CITY OF ALBUQUERQUE

PLANNING DEPARTMENT – Development Review Services

October 9, 2015

RE: Signal Point Subdivision (C20D070)
Retaining Wall and Scour Wall Concerns
Shown on Grading and Drainage Plan
Engineer Stamp Date: 9/15/15

CMU RETAINING WALL / SCOUR WALL

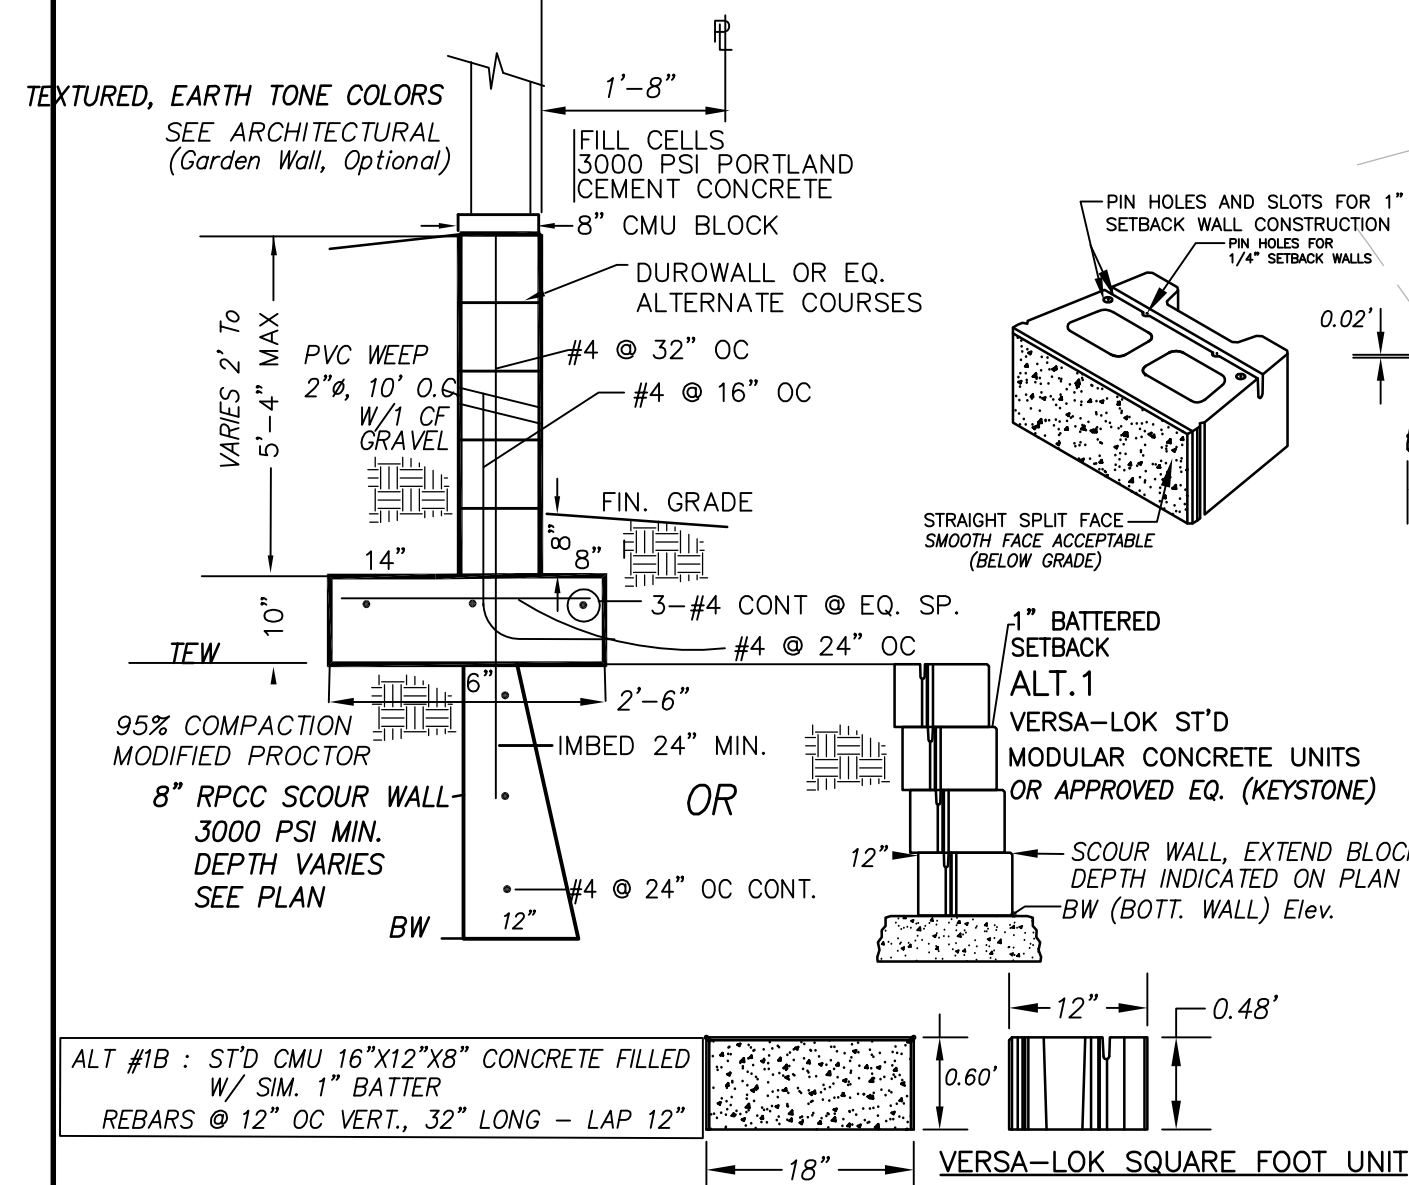
1. The Scour wall portion is being designed as a “key”. This is not an appropriate application of a key. A key is used to prevent sliding and is generally very short (4” to 12”). Once a key is longer than that, it must be designed to resist moment/rotation at the footing. Usually once a key is over 18” it becomes wide and requires heavy reinforcement, and it is better to widen the footing rather than increase the depth of the key.

2. To place the Scour wall below the retaining wall footing is not sound engineering practice. Once the soil below the toe has scoured away, the retaining wall has lost most of its bearing resistance and will likely fail in soil bearing, overturning, and sliding.

3. Keystone walls are not generally used as scour walls. Without a solid monolithic face, water eventually erodes the joints and seeps behind the wall, possibly undermining the soil stability behind the wall. The manufacturer would have to provide documentation stating that the product has been designed and tested to serve as a scour wall.

4. Scour walls are designed with the scour depth above the footing. Generally, there is some guidance given in AASHTO and other codes as to what this depth should be. Furthermore, a keystone wall does not have a solid monolithic footing (see comment below).

5. In general, the monolithic structural elements (such as concrete walls/slabs) are used for scour or any condition where the wall may be exposed to water, particularly moving water. This is because any undermining of the soil at a single point would allow for load transfer. A Keystone or block wall with discontinuous elements would not allow for such a load transfer.

6. Retaining walls must be designed, taking into account the Dead Load, Wind Load, and Seismic Load of any supported garden walls which bear on them. These loads add significantly to the Soil Bearing Pressure and Overturning Mechanisms
